# CITY OF ALBUQUERQUE

RE: **Volcano Cliffs Subdivision Lot 7 Block 8 Unit 18**  
**6509 Canavio Pl NW**  
**Grading and Drainage Plan**  
**Engineers Stamp Date 1/30/17 (D10D003O7)**

**GRADING AND DRAINAGE PLAN**  
**LOT 7, BLOCK 8, UNIT 18, VCS**  
**ADDRESS: 6509 Canavio PL NW**

PREPARED BY STEVEN J. METRO, PE AND PS GRADING & DRAINAGE PLAN 6509 Canavio Pl, NW LOT 7, BLOCK 8, UNIT 18 VCS

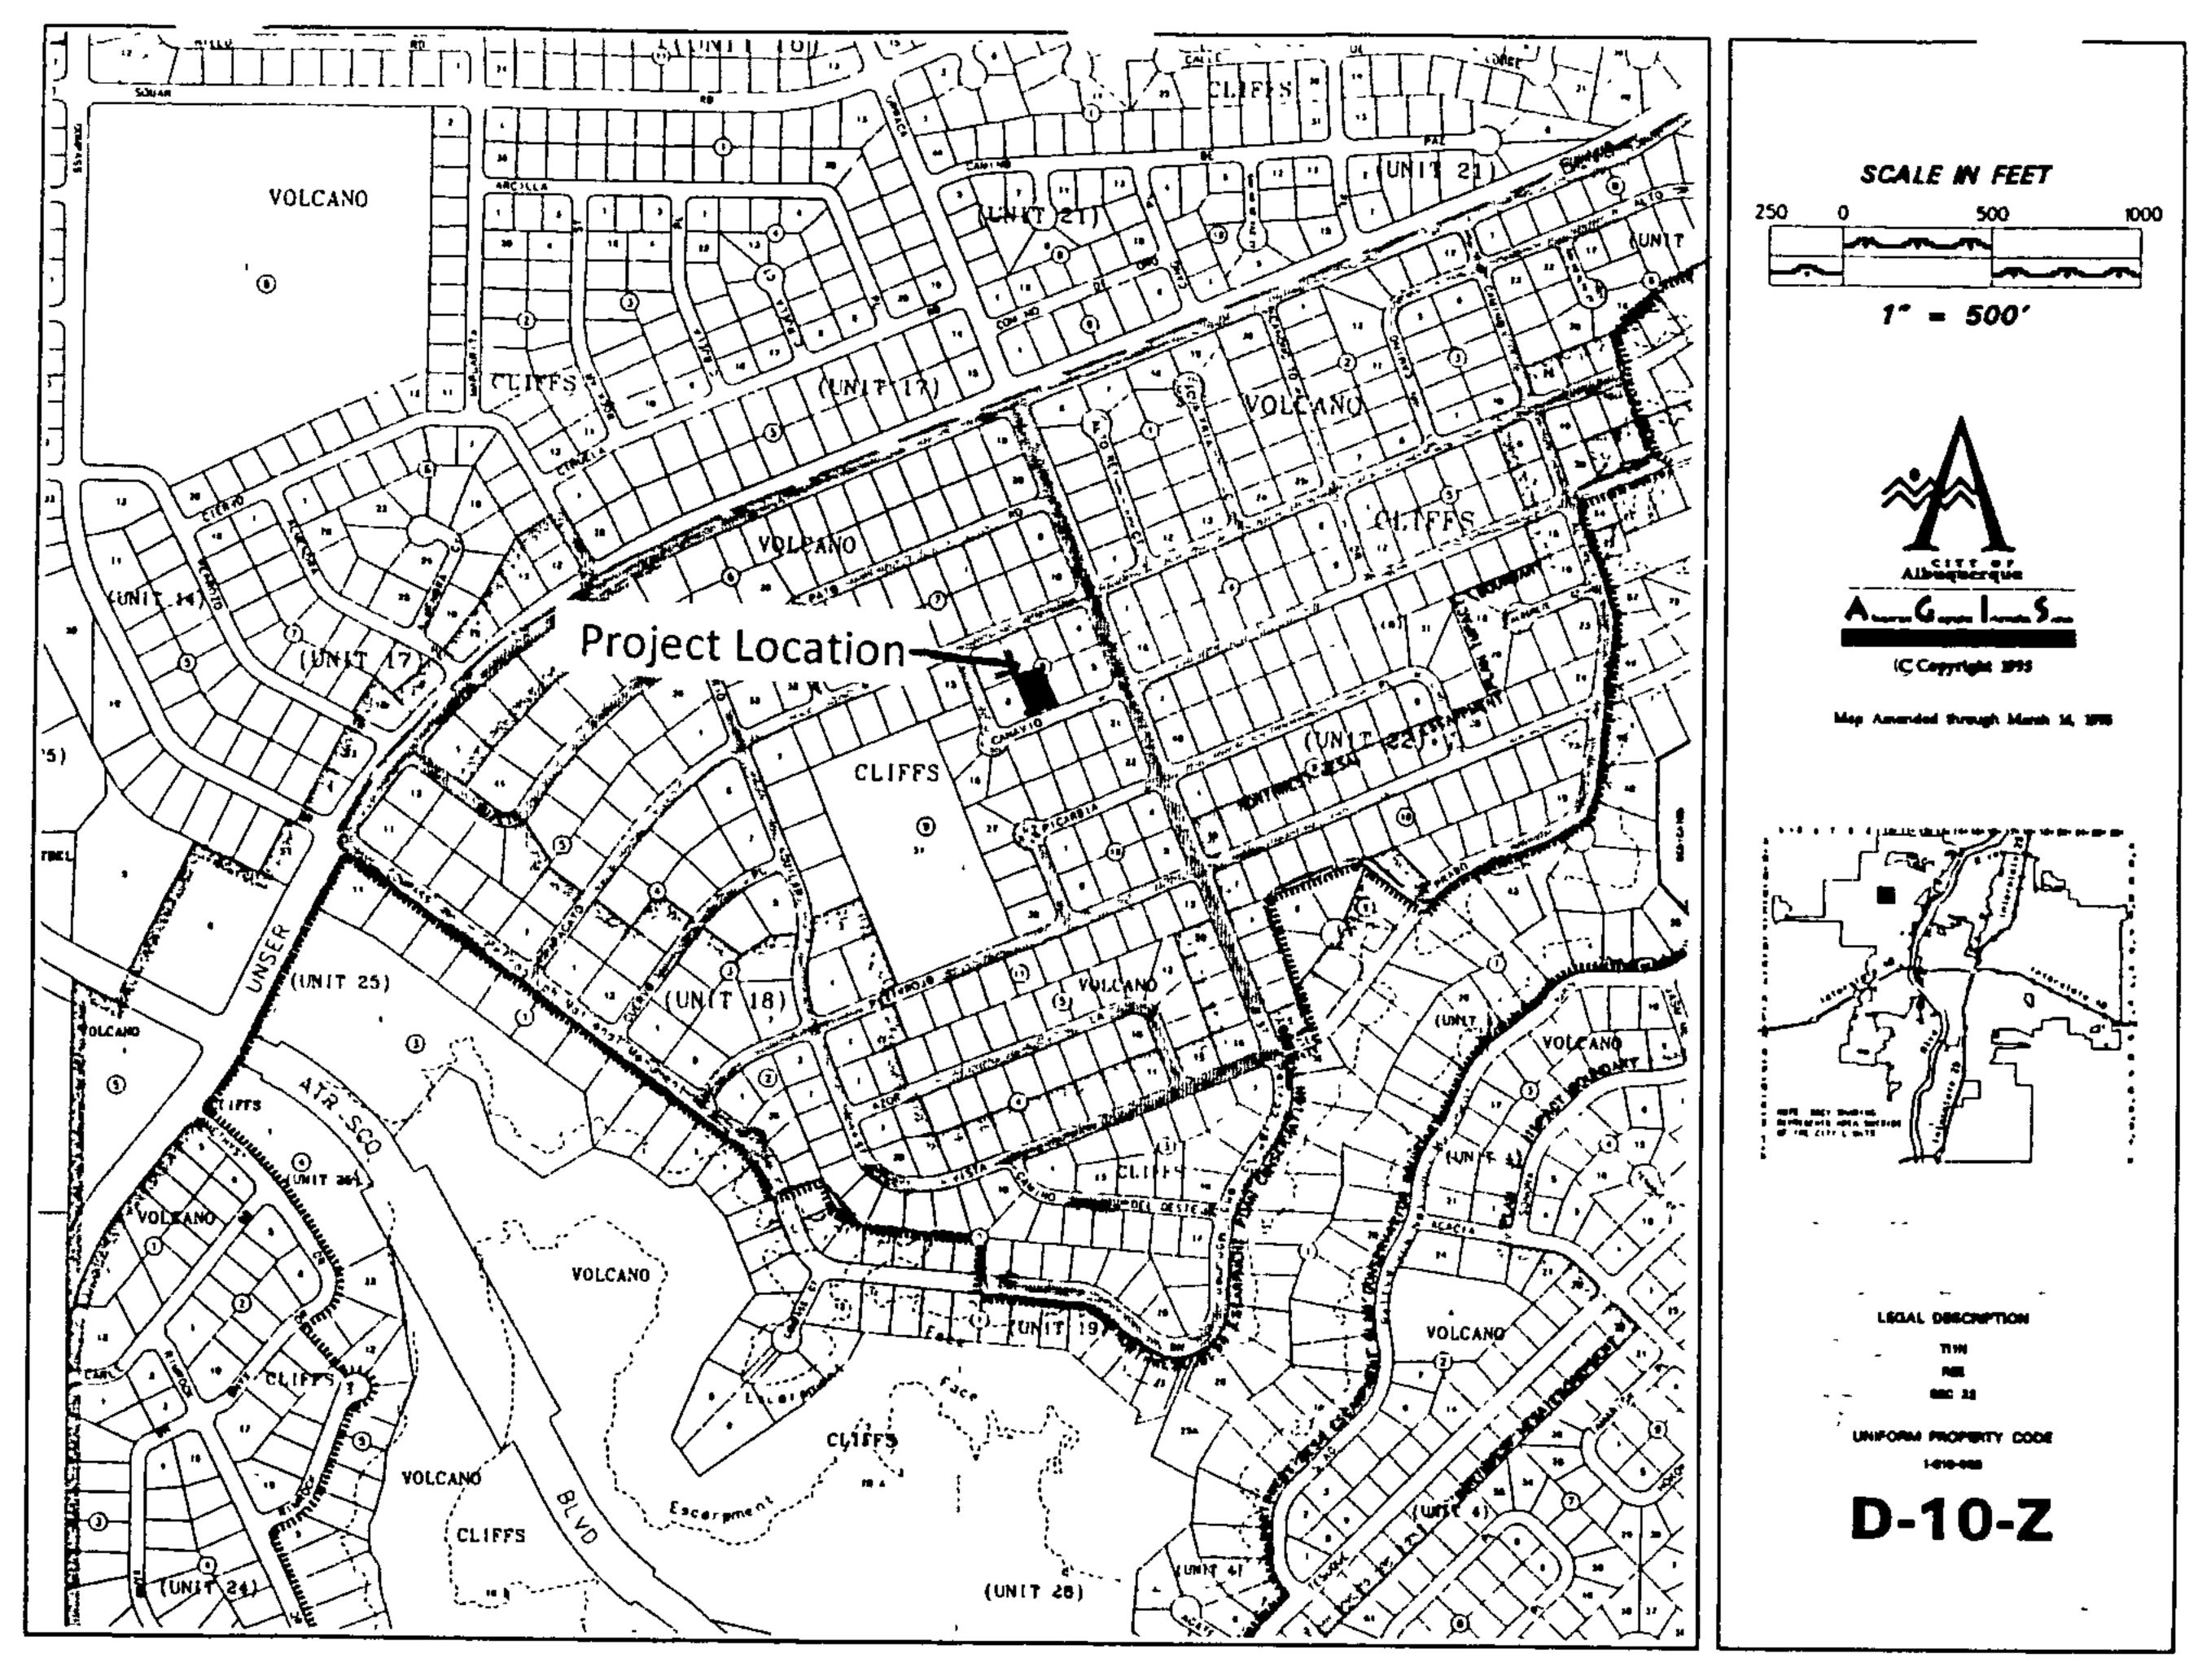
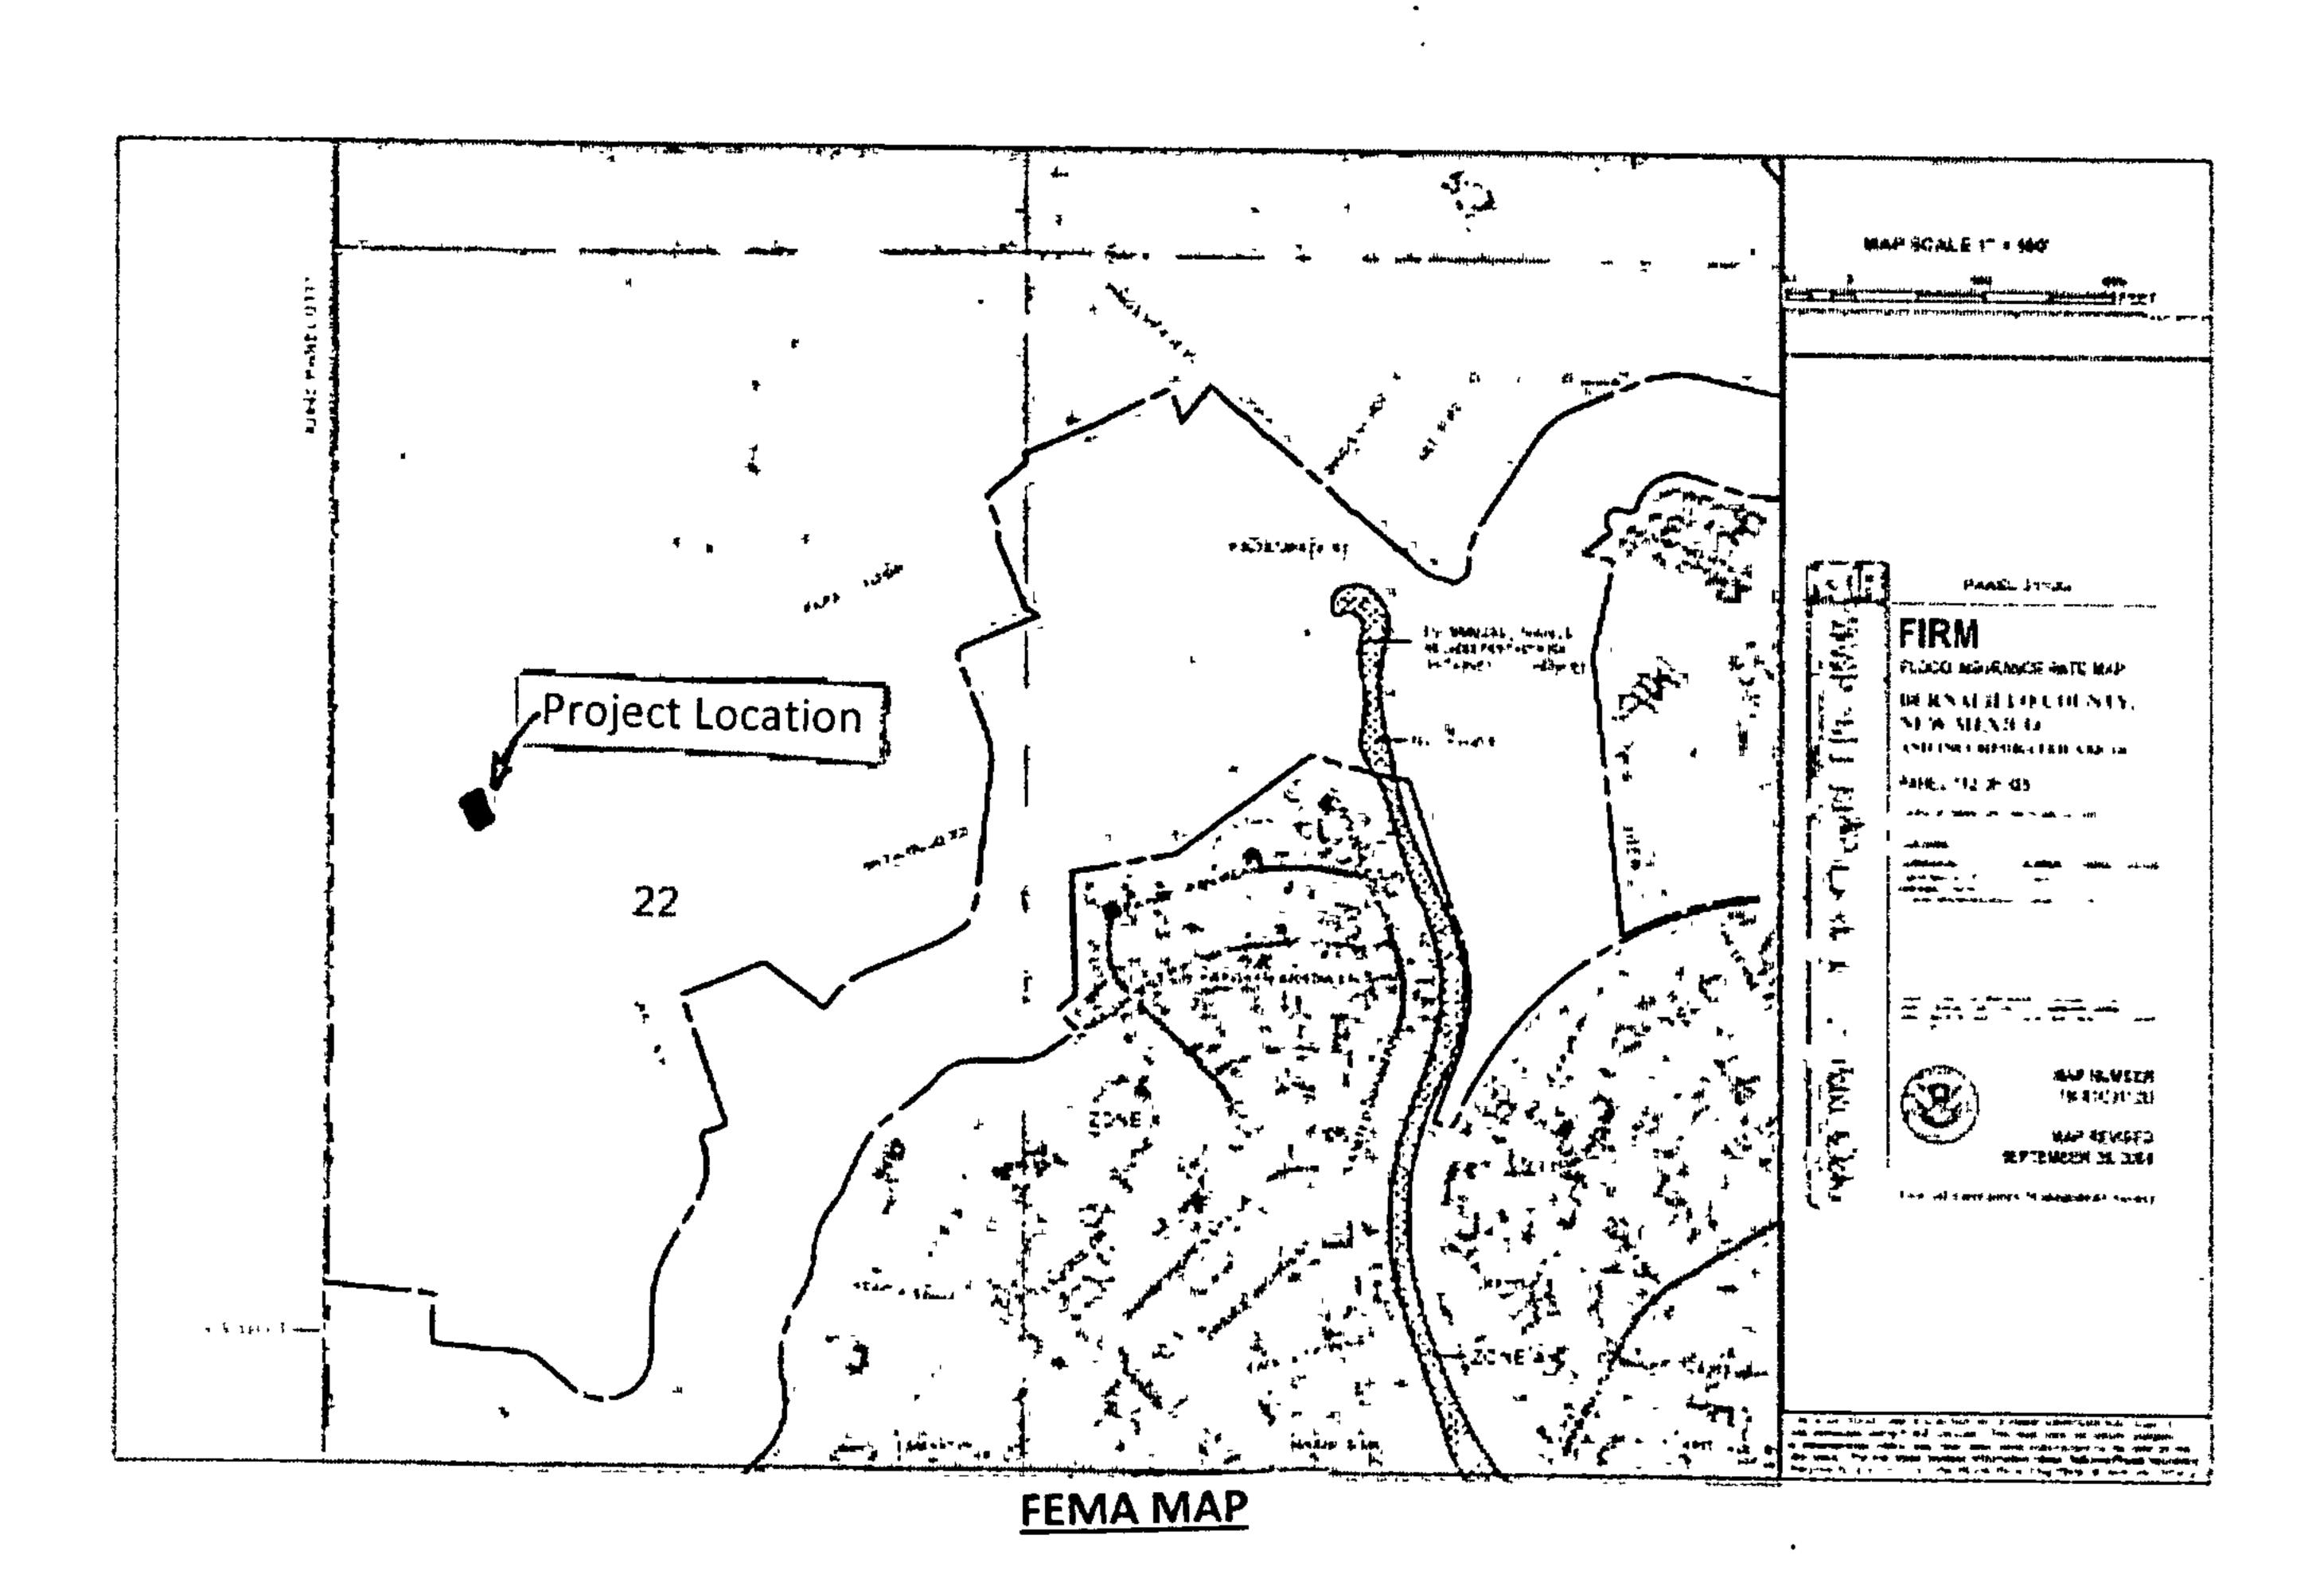
Please attach a copy of this approved plan to the construction sets in the permitting process prior to sign-off by Hydrology. Also, please advise the owner/contractor that a separate wall permit must be obtained and this approved grading plan dated 1/30/17 must be provided with the wall permit application. Also, please advise the contractor/owner that the ponds must stay in place or CO will not be granted.

- Provide a note stating that future garden walls require a separate permit and this plan should be used for their placement.
- Provide a statement that a pad certification is required before a building permit is given.

1. Future garden walls will require a separate permit and this plan should be used for their placement.
2. A pad certification is required before a building permit will be provided by the City.
